Crumhach Wind Farm, Co. Sligo

Stage 1 Road Safety Audit

Alan Lipscombe Traffic and Transport Consultants

August 2026

Proposed Use:

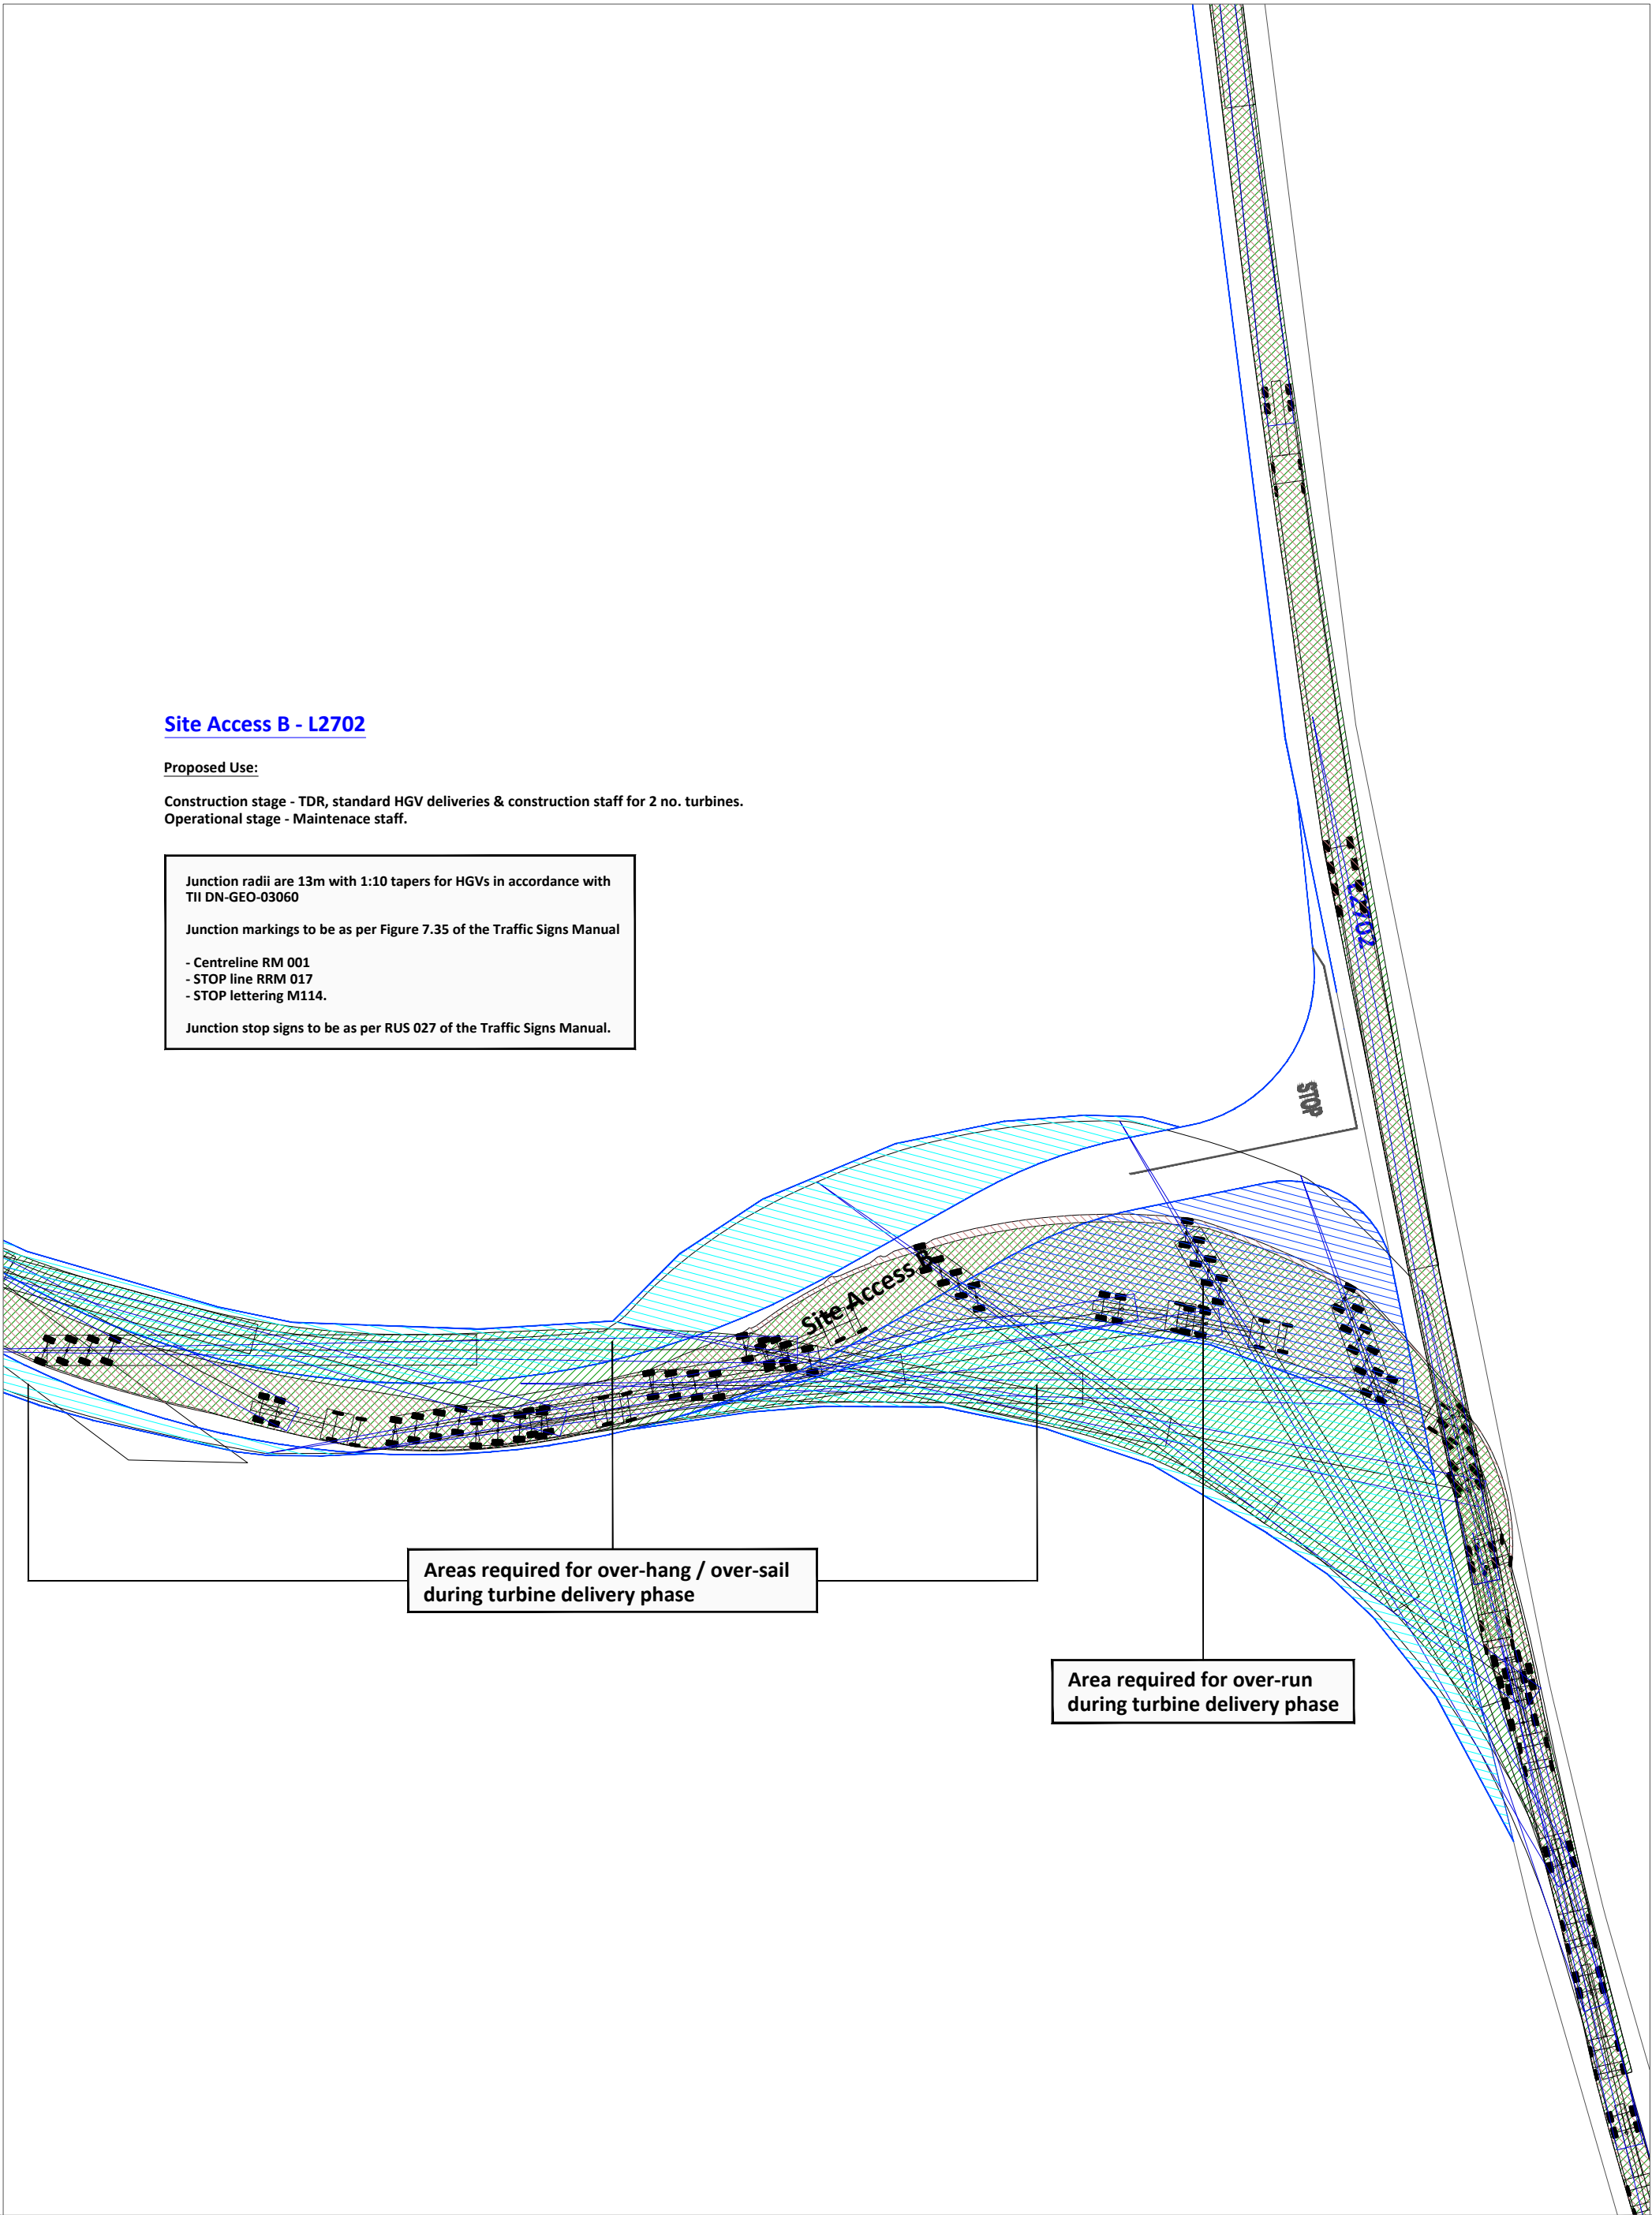
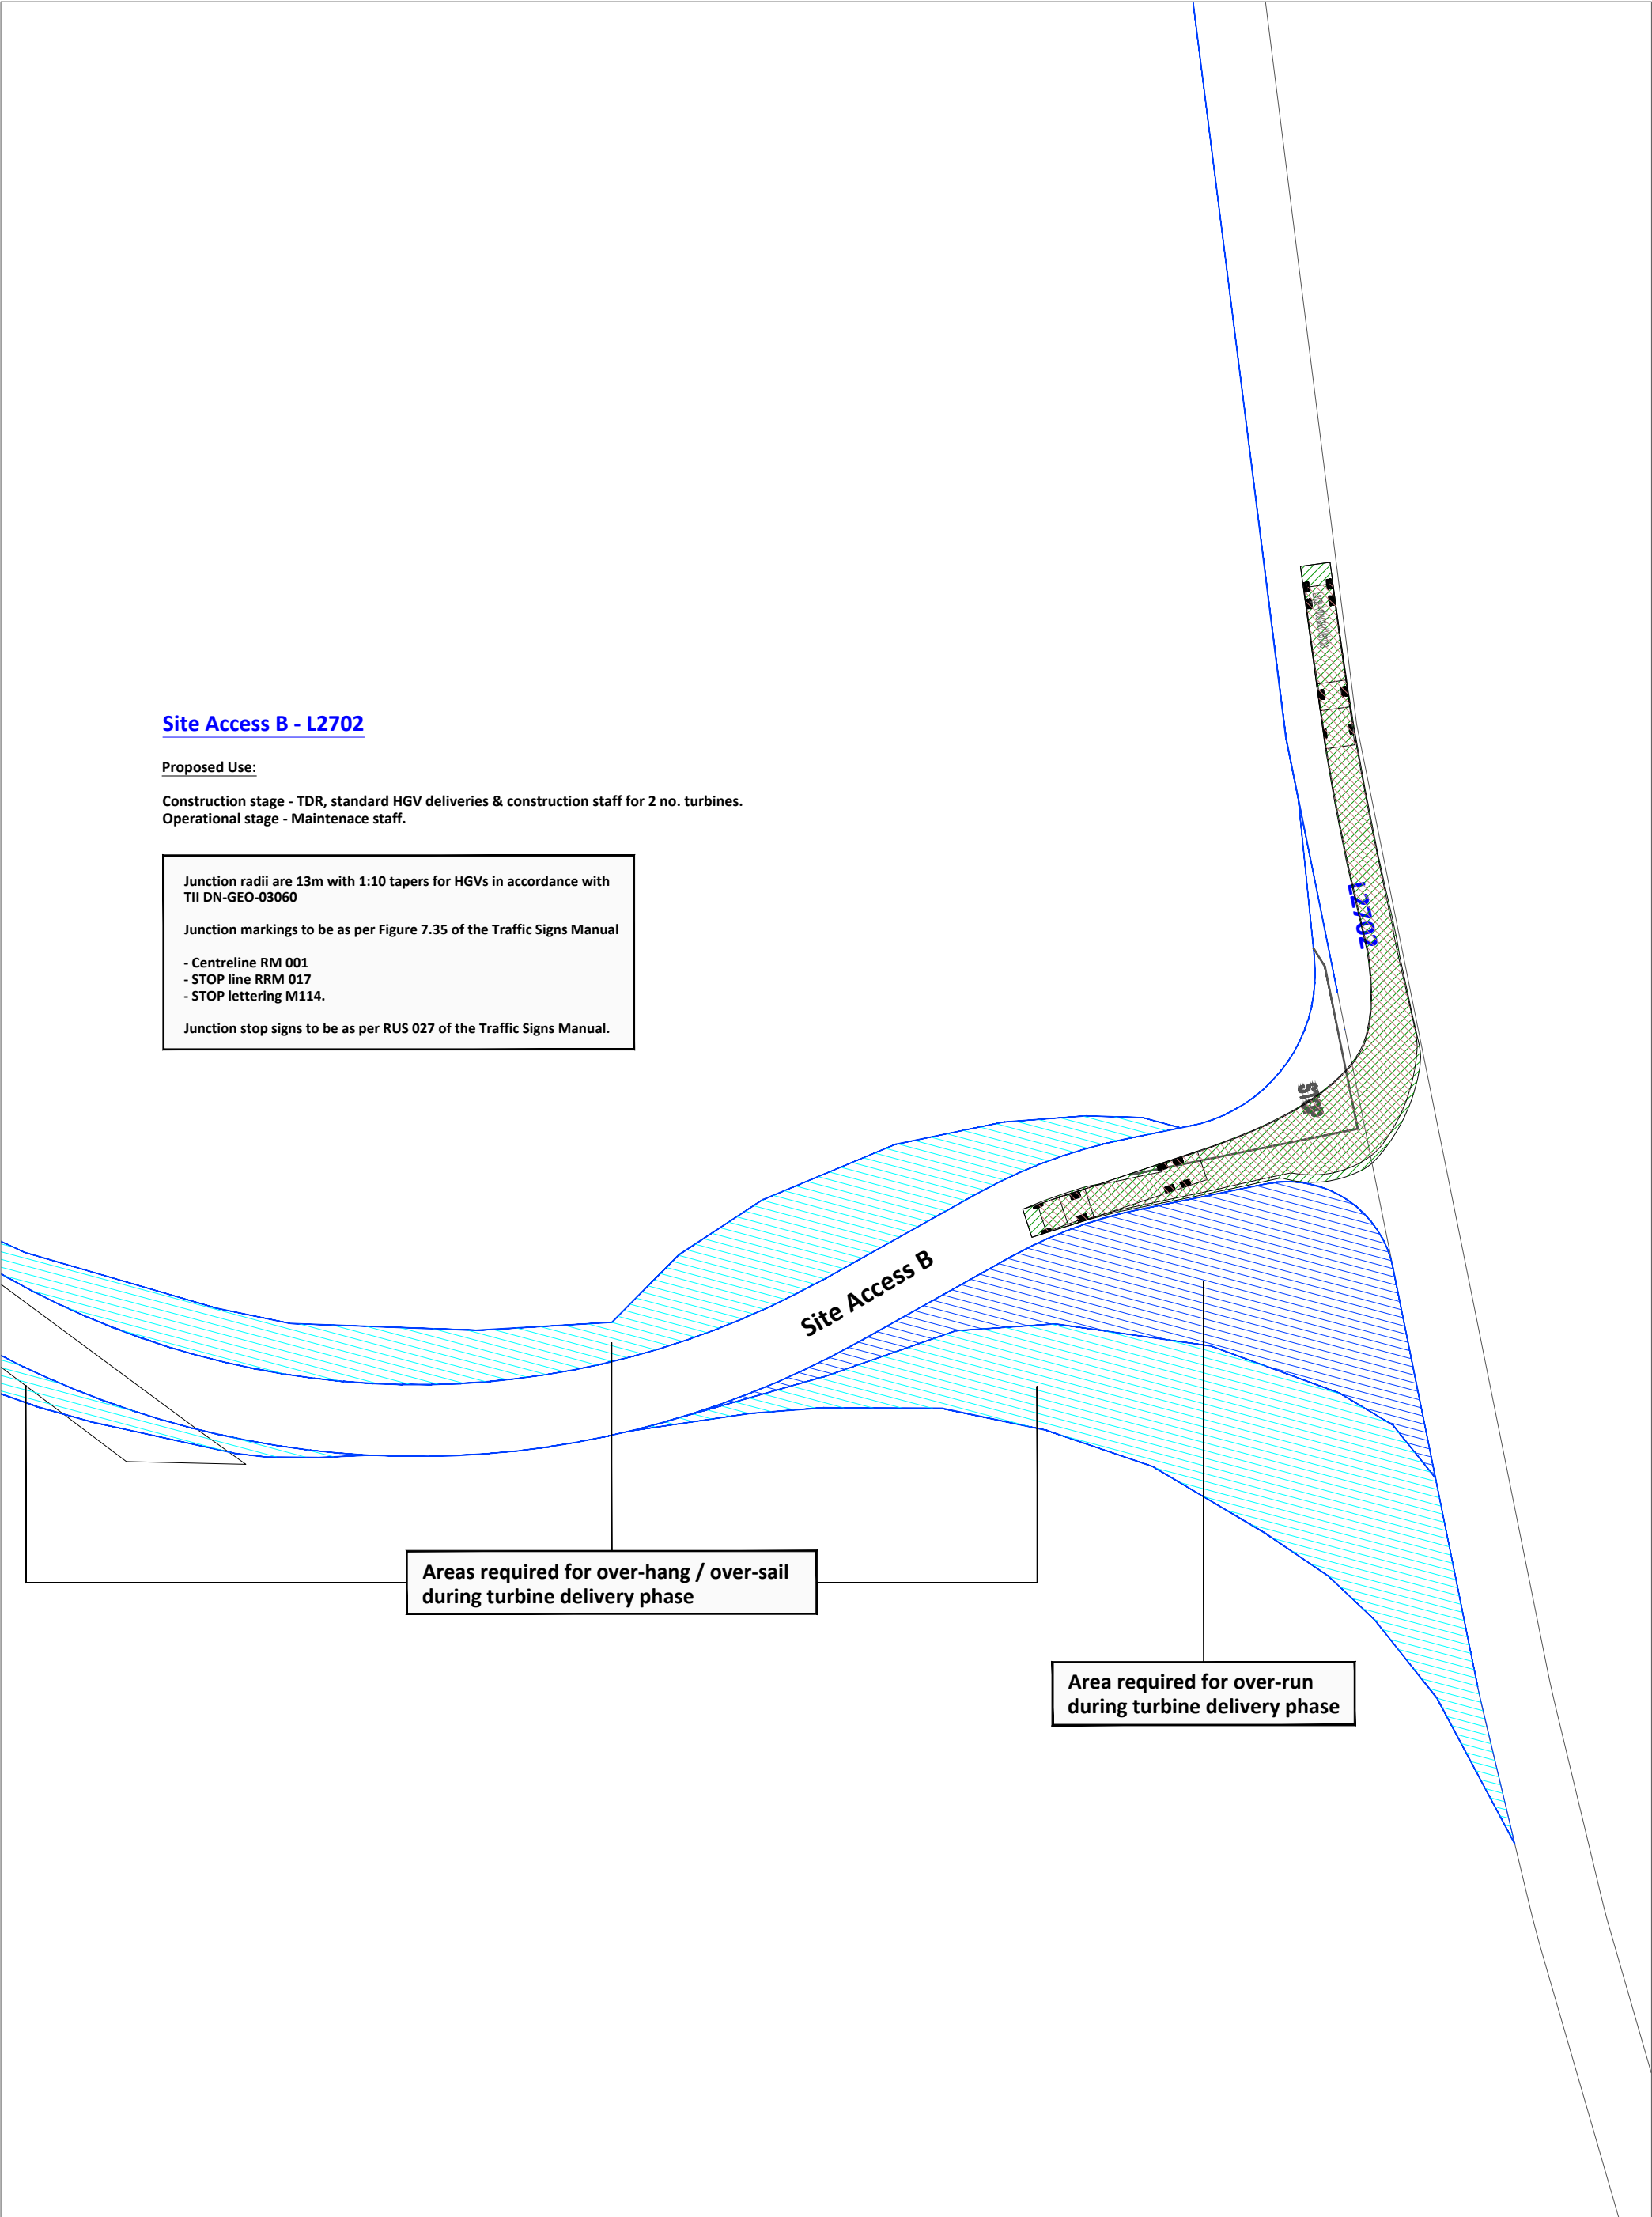
2.2 Problem: Drivers Confused by Redundant Access Track

Location: Site Access B – Local Road L2702, Existing Access Track to South

The existing section of access track (made redundant by Site Access B) might create confusion for drivers who could enter it by mistake, leading to sudden braking, loss of control or conflicts with construction traffic.

Recommendation

The section of redundant access track should be removed.

2.1	Access A For Record Purposes Only. No Safety Issues Identified.			
2.2	Yes	No	It is proposed that the existing access will be retained for local access only and managed during the construction phase. It is proposed that both accesses are gated with the opening of each access managed on site during the construction phase. On the completion of construction the over-run areas will be closed off permanently. Appropriate signage will be put in place at both the existing and proposed new access tracks to clearly distinguish the existing access for local landowners from construction and operational access to the Proposed Wind Farm.	Yes
